From: [Weston Parish Council](#)
To: [Great North Road Solar](#)
Subject: Weston Parish Council comments Solar Farm in Newark & Sherwood Notts
Date: 08 December 2023 08:10:45

Comments from individual Councillors (1 abstained):
"Environmental impact assessment scoping - Great North Road Solar Park

1:30,000 Scale @ A3

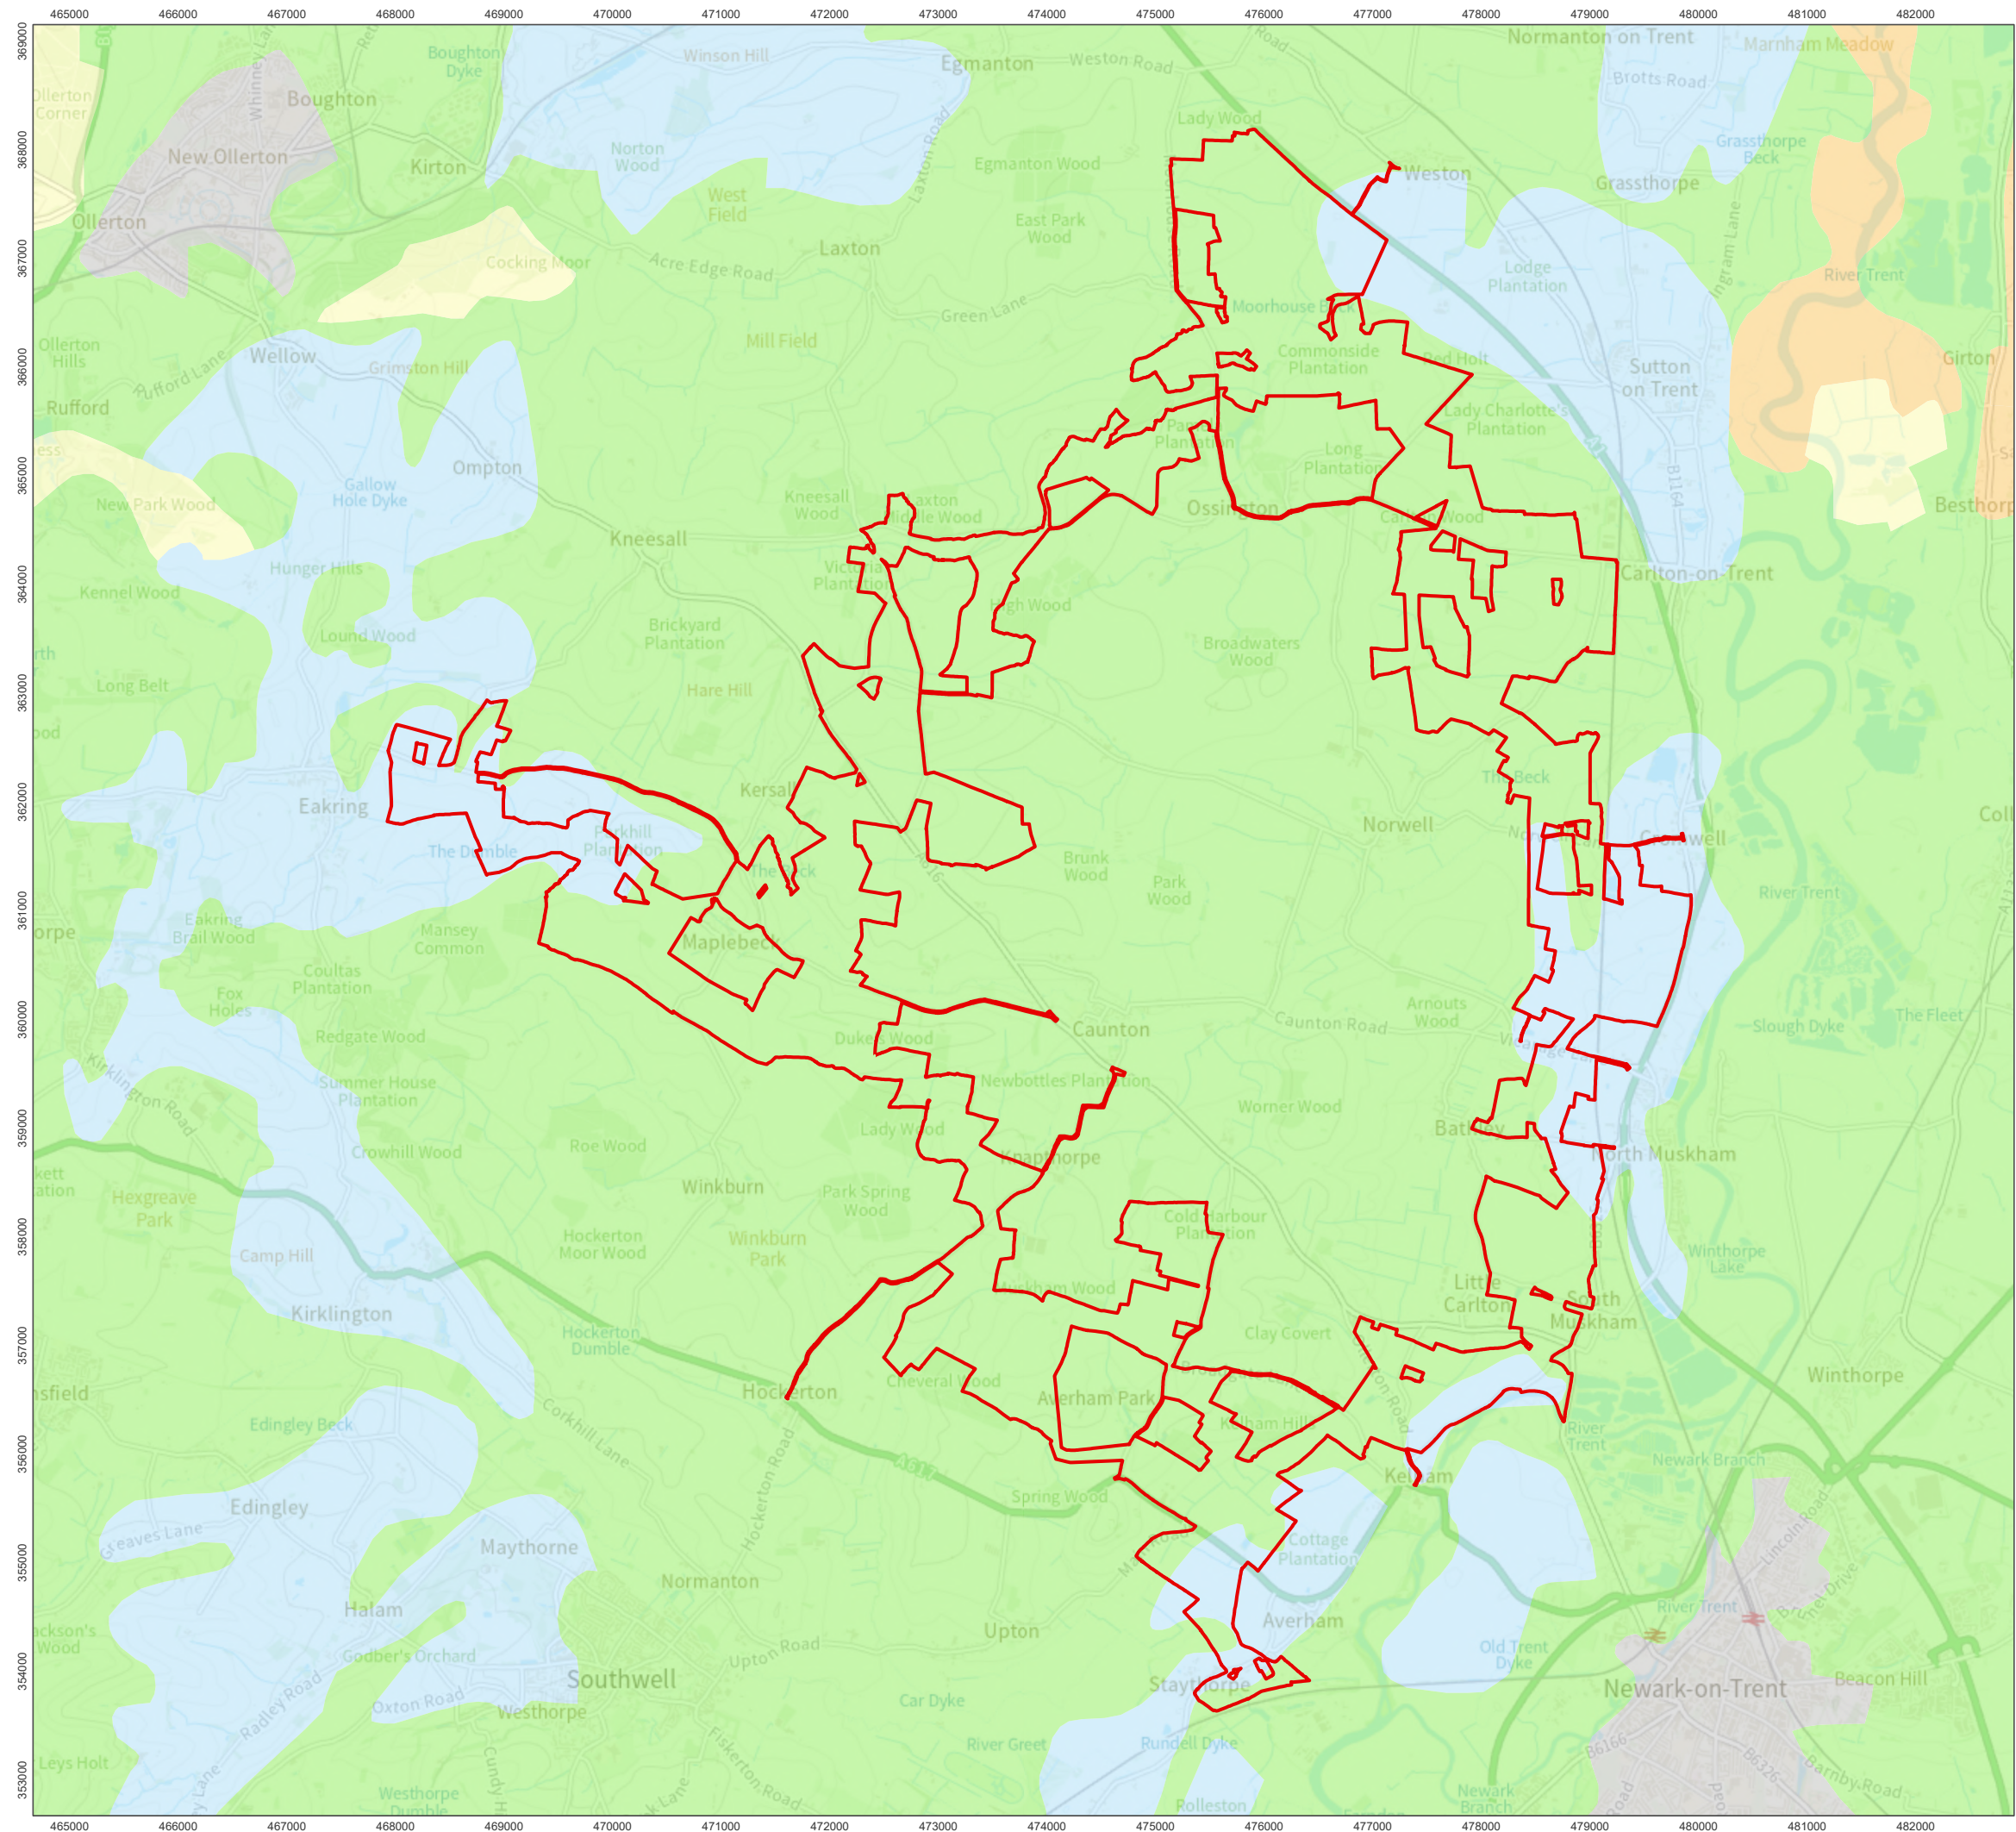
Disruption to walkers and horse riders to footpaths and bridleways during construction phase. Nine footpaths and one bridleway will be affected.

Provisional Agricultural Land Classification Figure 10.2

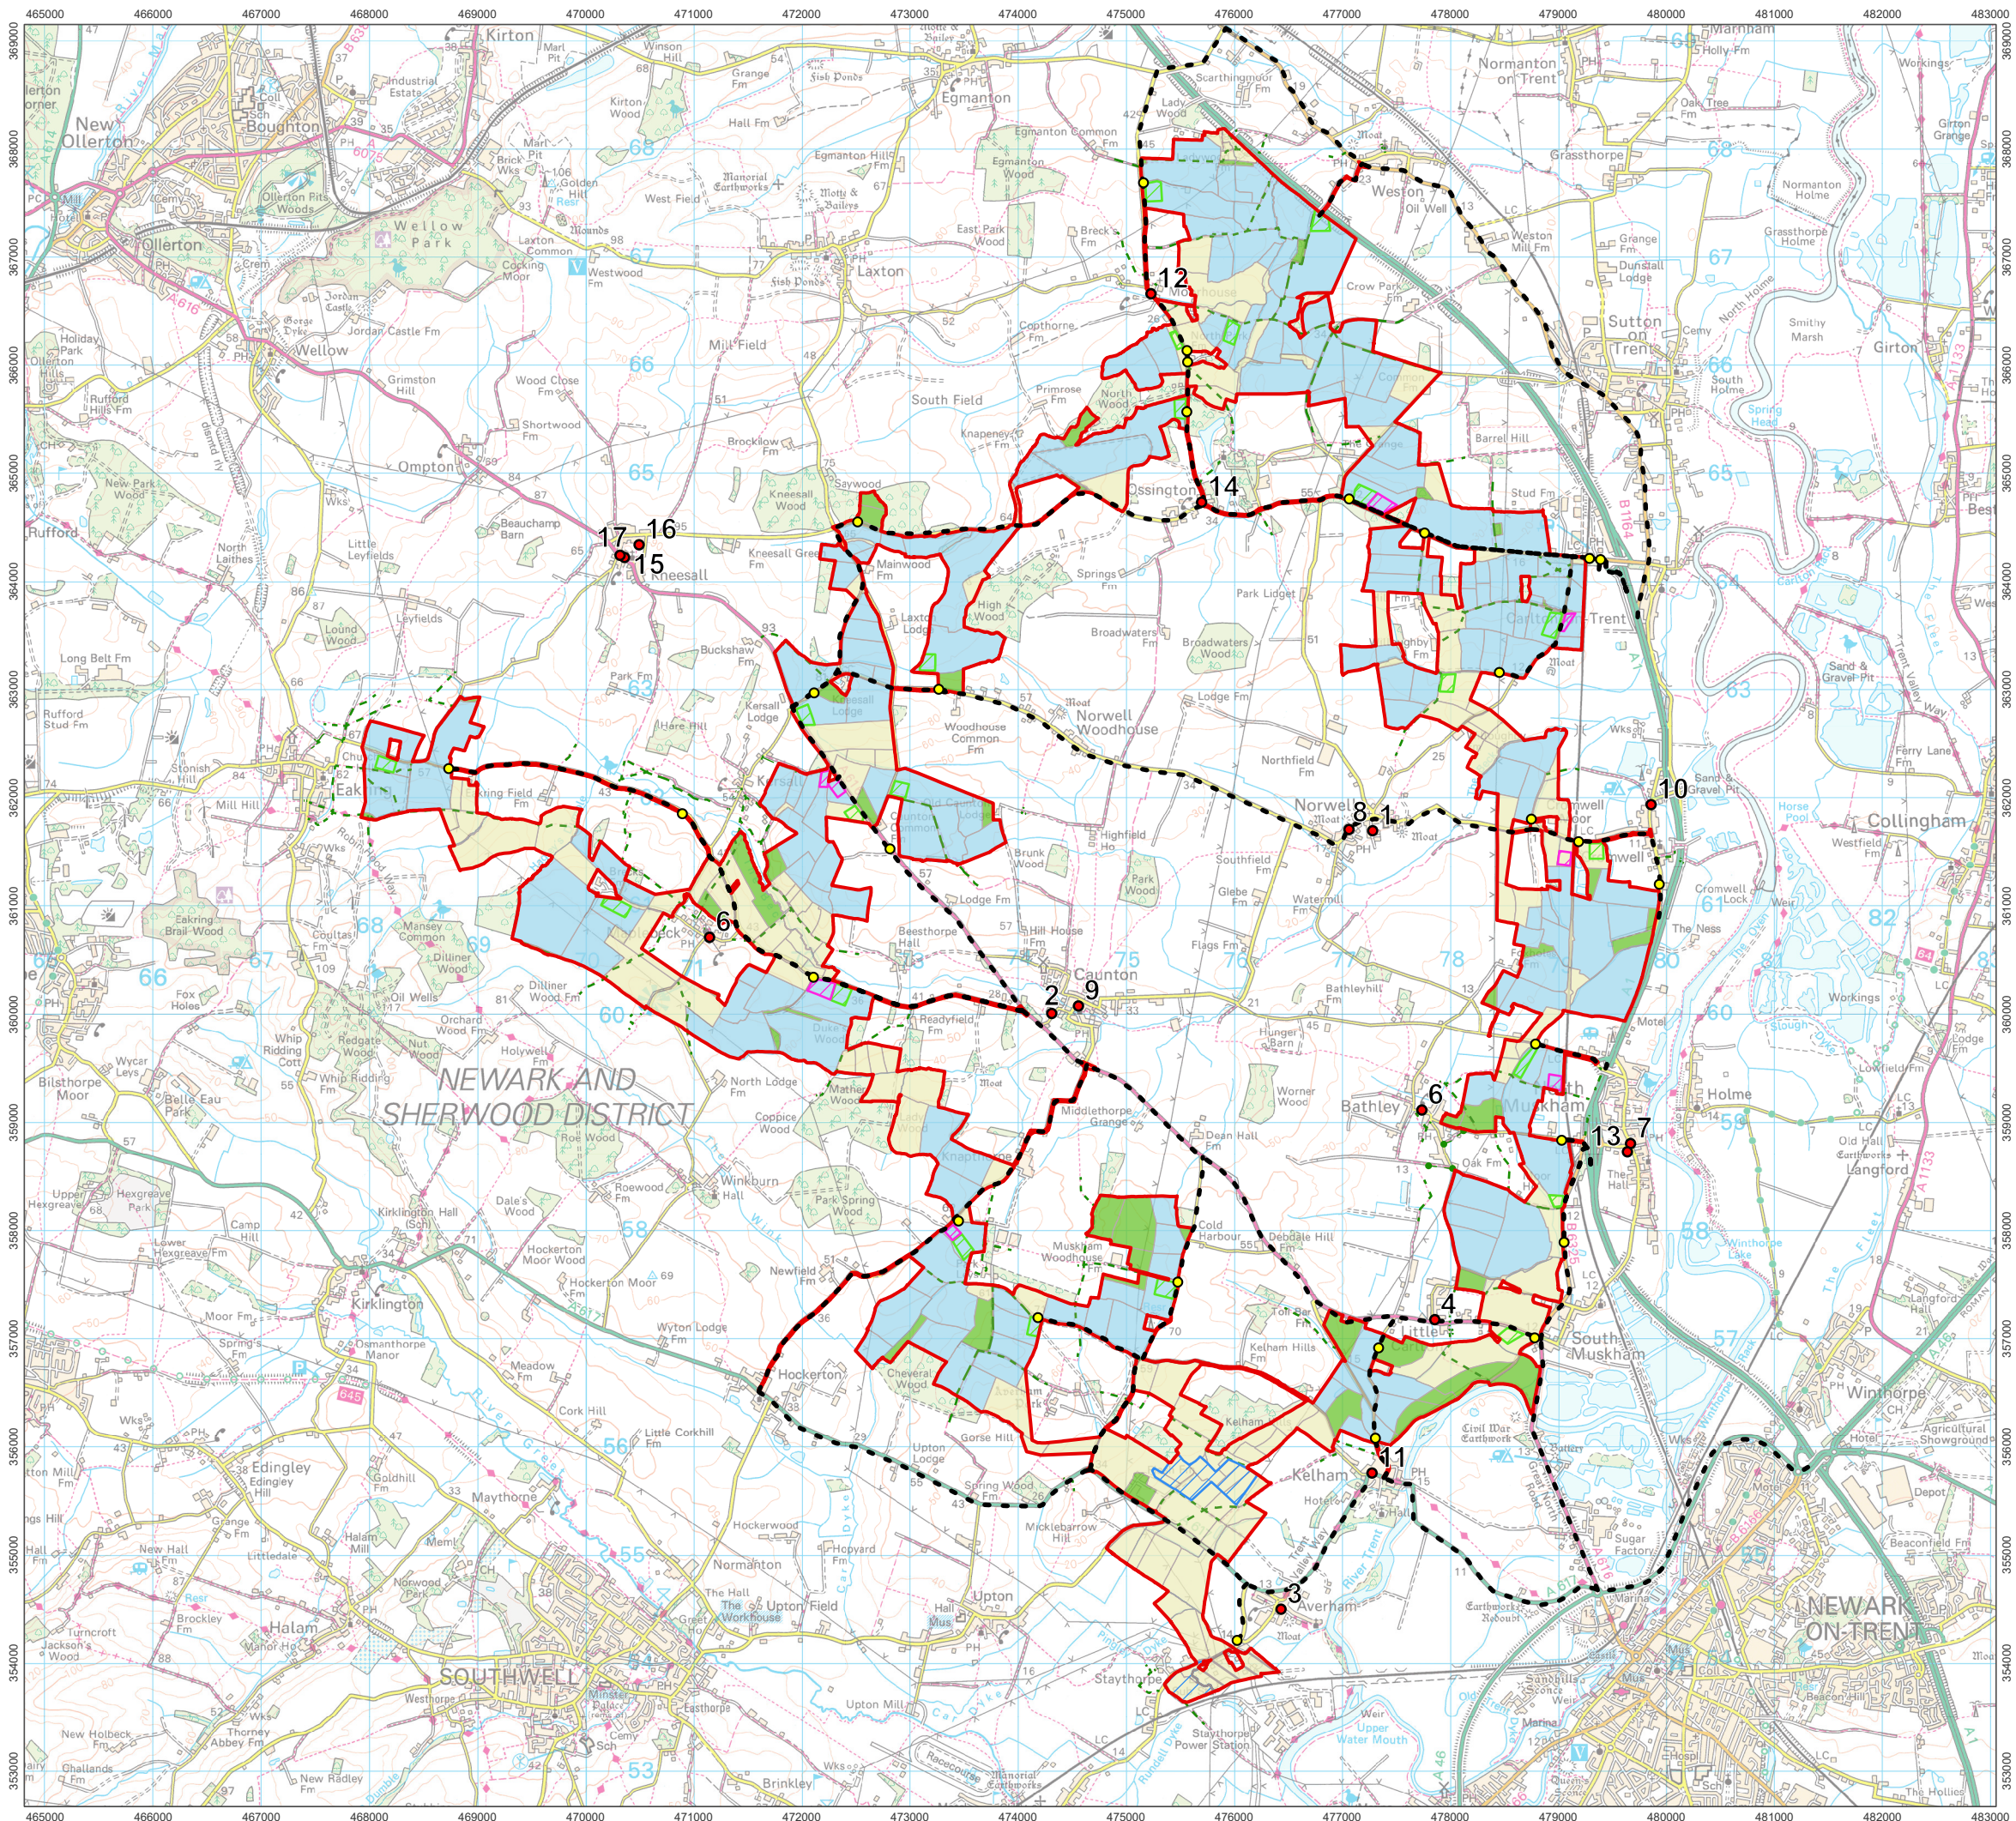
The proposed solar park is excessive and would take up too much valuable productive land

The change of land use from arable soils to grazing land will have a detrimental effect on the

land and will take a long time to get back to fertile land again after the 40 year period.

Land

use report from Keron Countryside Consultants Limited not available with the environmental

impact assessment scoping report discussing loss of Grade 1 to 5 high productive land over

the proposed Solar Park scheme.
